DATE: August 11, 2015 Revised: August 17, 2015
TO: Jack Cloud, DRB Chair
FROM: Catalina Lehner, Senior Planner
RE: Project #1010458, Armory Park
Zone Change & Site Development Plan for Subdivision

Staff reviewed an updated version of the site development plan (v.3, dated August 4, 2015) and notes the following:

Re: Final Sign-off of Site Development Plan for Subdivision, Armory Site Park -
Project# 1010458/15EPC-40018

A1 SITE PLAN FOR SUBDIVISION
SCALE: 1"=30'-0"

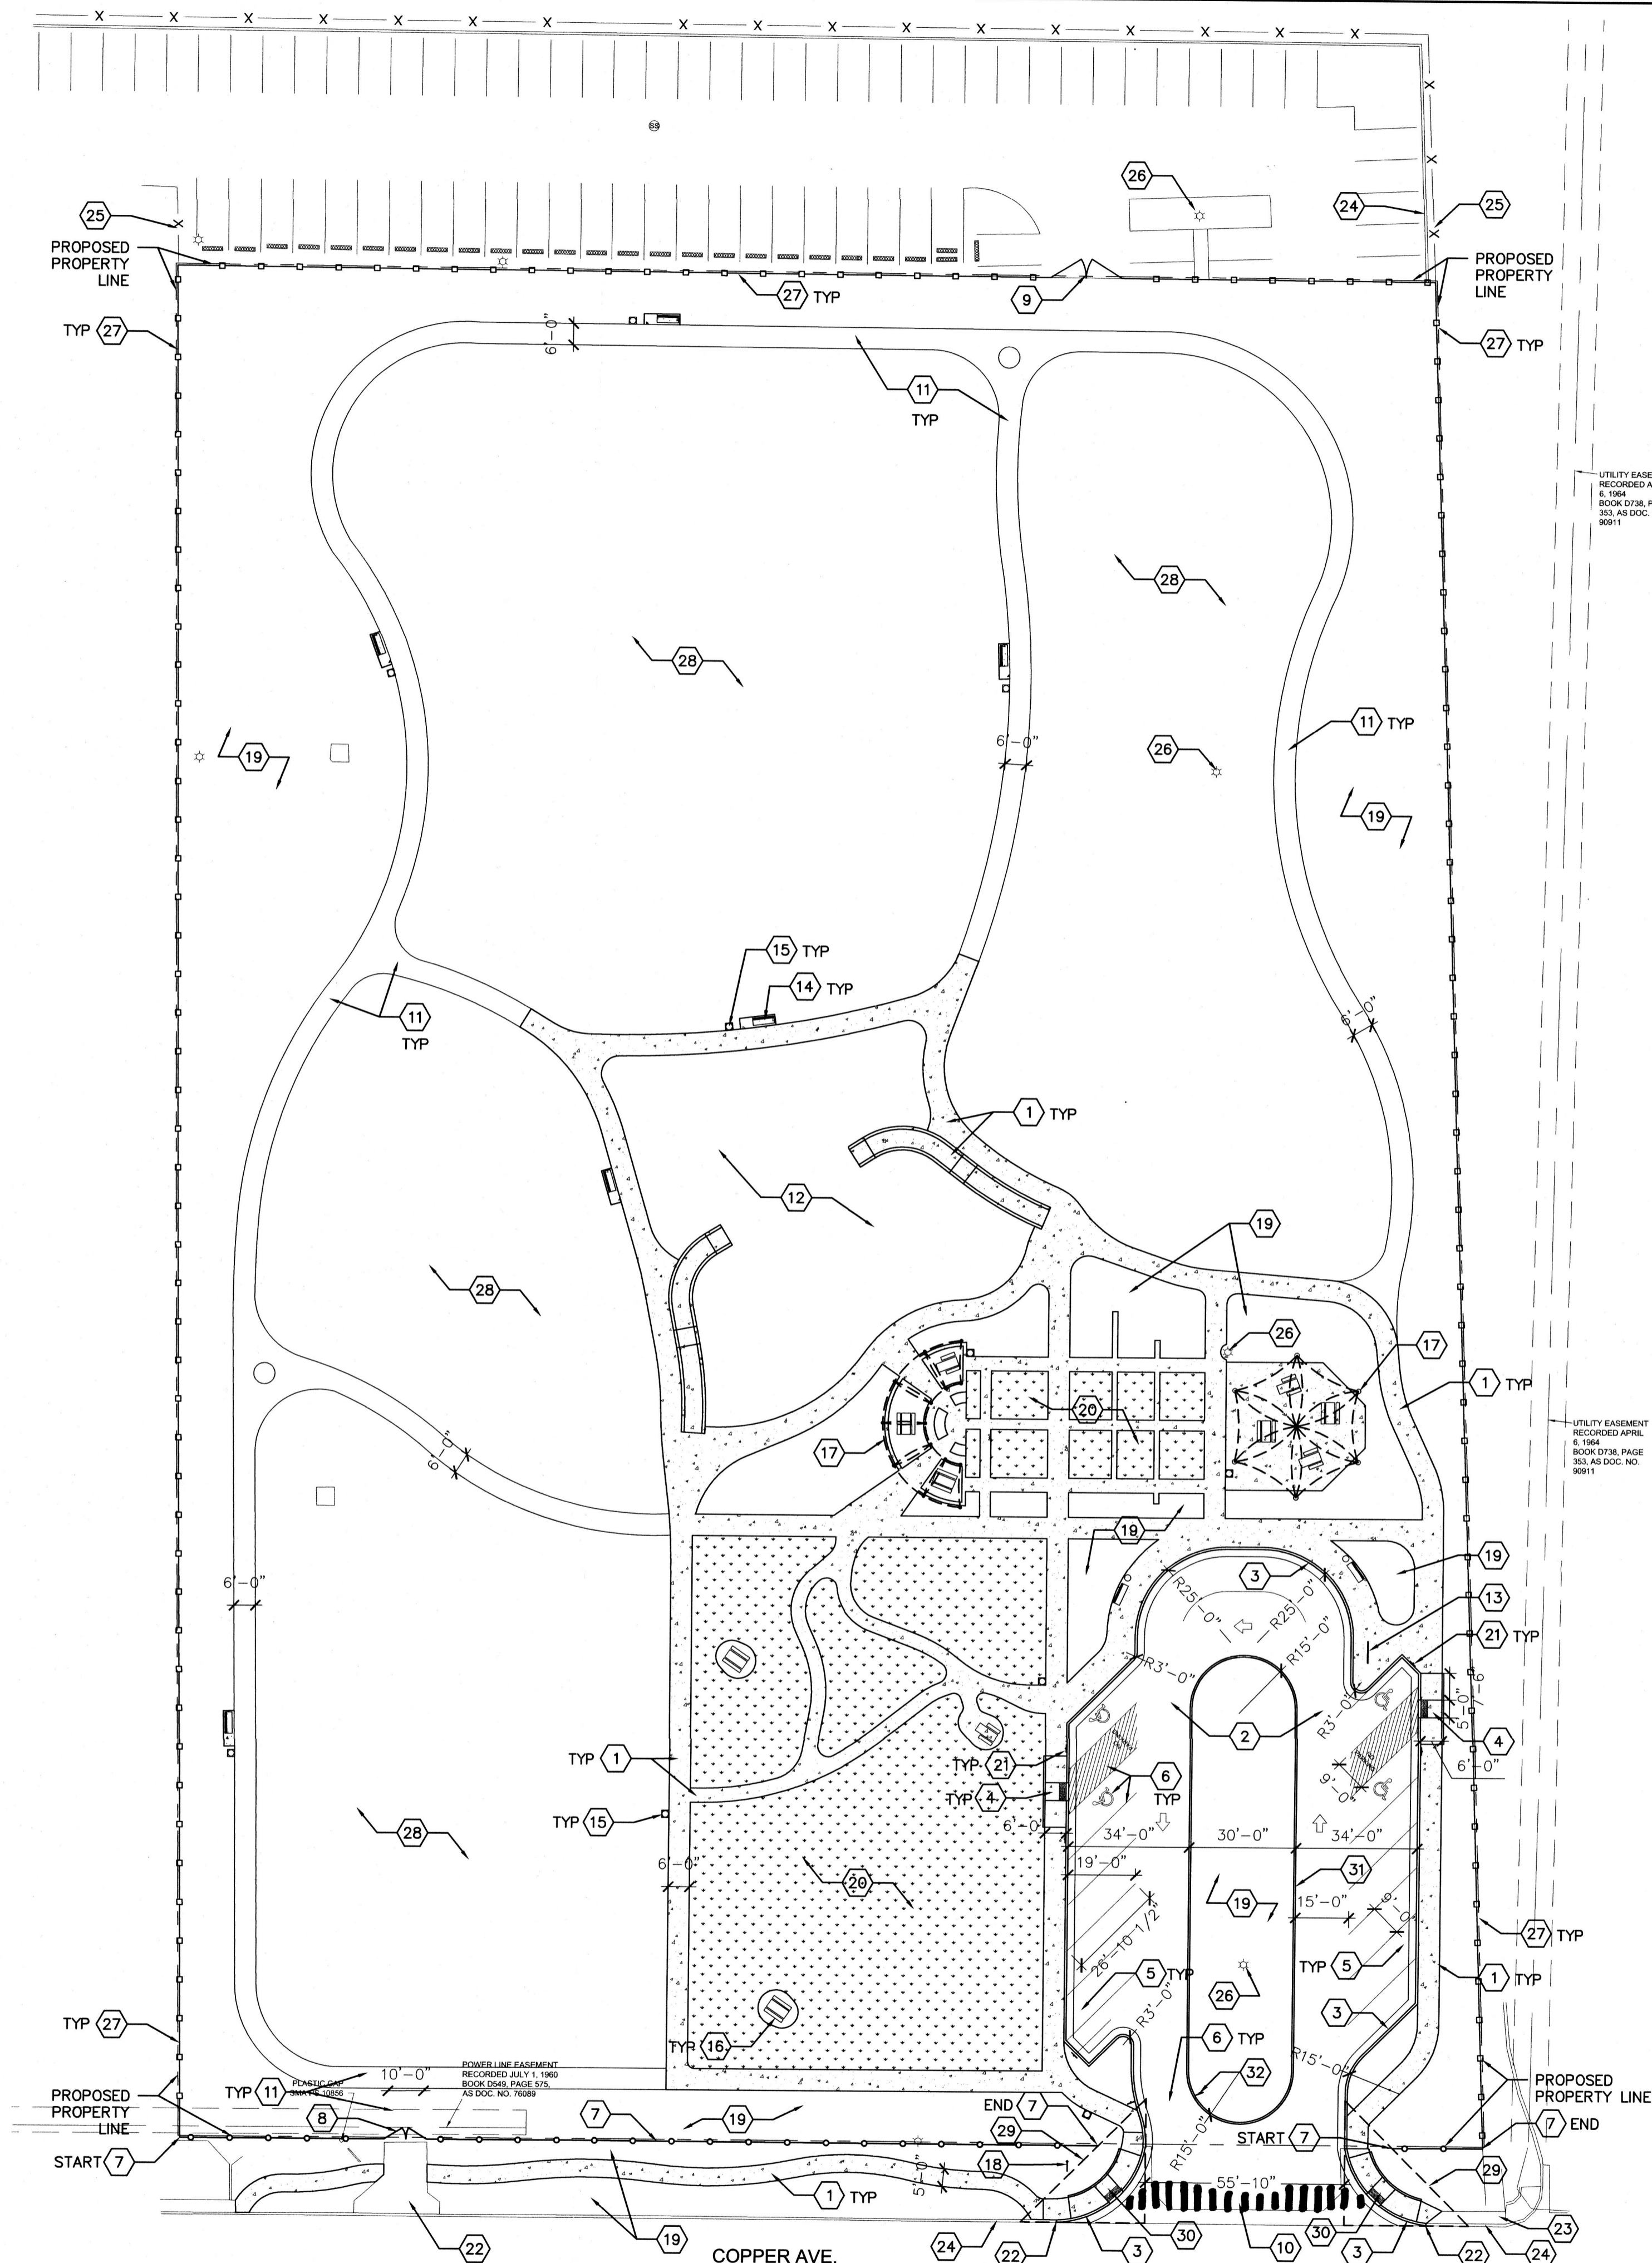
5. Staff notes two more minor changes from what the EPC reviewed, in addition to the four itemized in the August 4, 2015 letter:
 - a) the pathway on the site's eastern side was reduced from 10' to 6' wide, and

- b) note #10 used to call for "concrete plaza paving per COA standard dwng 2720, similar, with integral color" and was changed to "crosswalk pavement marking".

**The changes are in substantial compliance with the EPC approved site plan, therefore can be processed thru the DRB for final sign off by Planning. Kym Dicome, Current Planning Manager
8-17-2015**

MATCHLINE
SEE GRADING AND DRAINAGE PLAN - NORTH

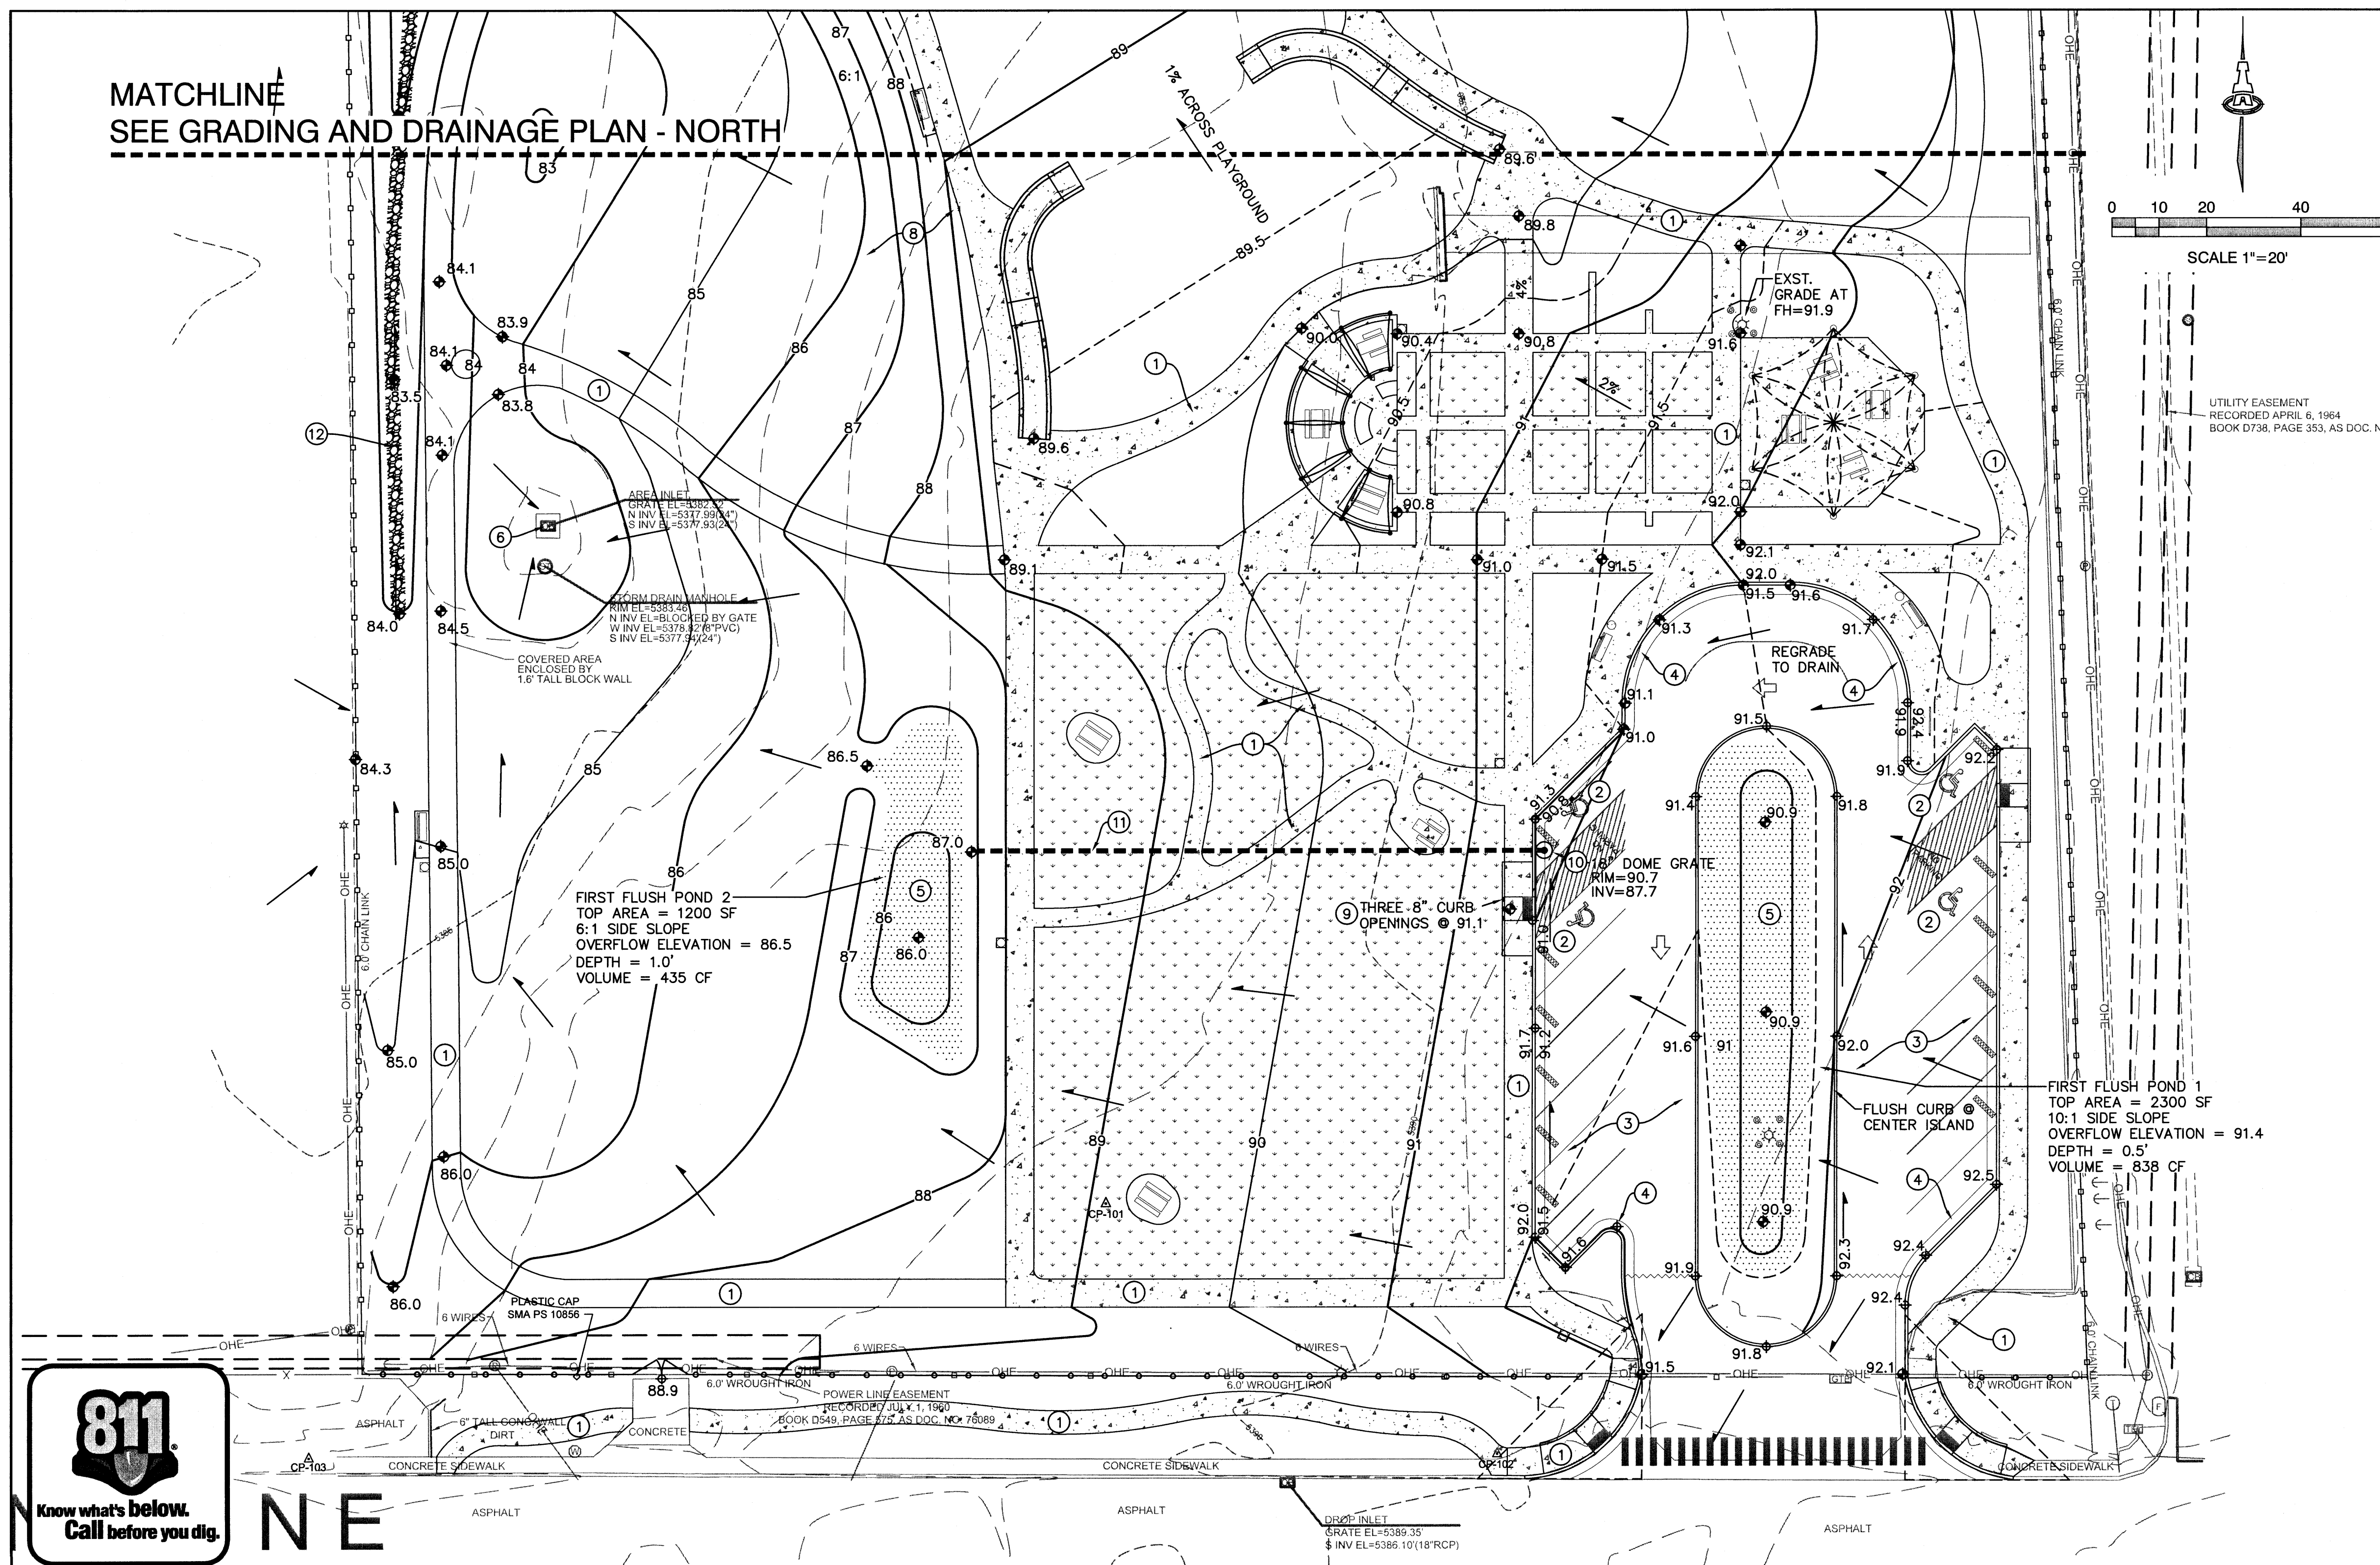
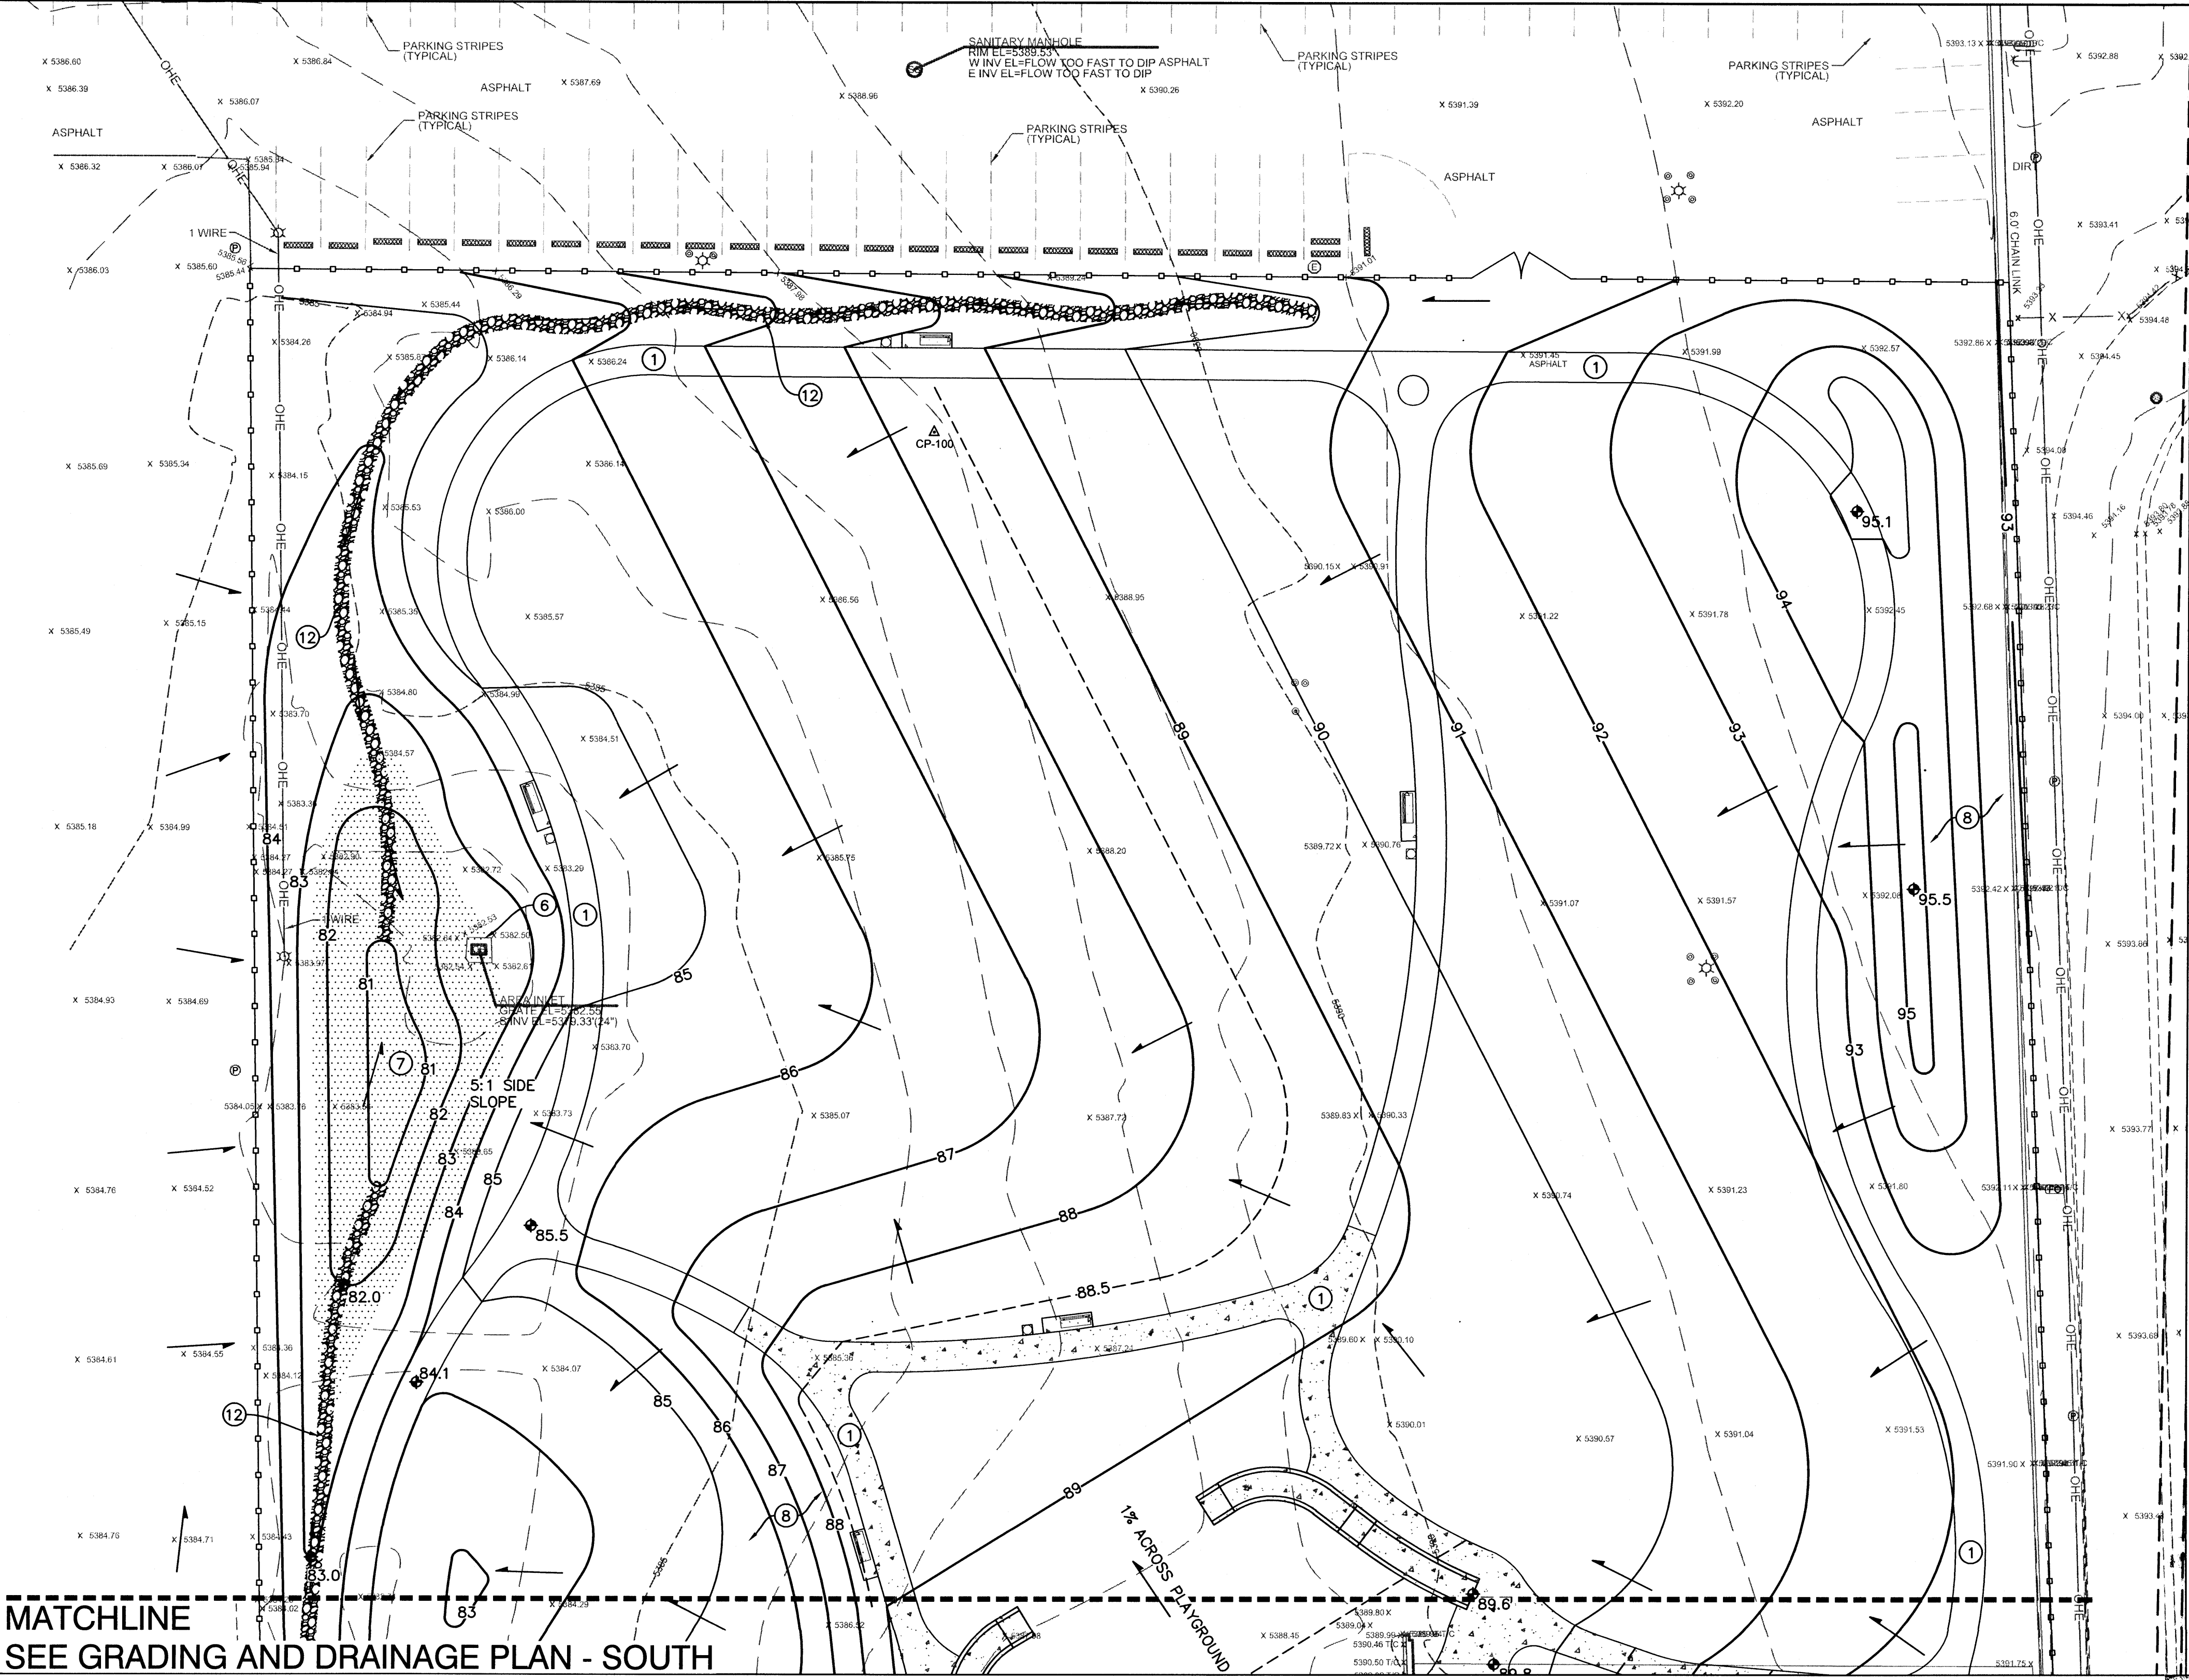
1. All of the EPC's conditions of approval were incorporated into v.3 and are met (please see #4 and #5, below).
2. The Grading & Drainage Plan (sheets 3 and 4) was not part of the EPC review, but was added to fulfill Condition #11.
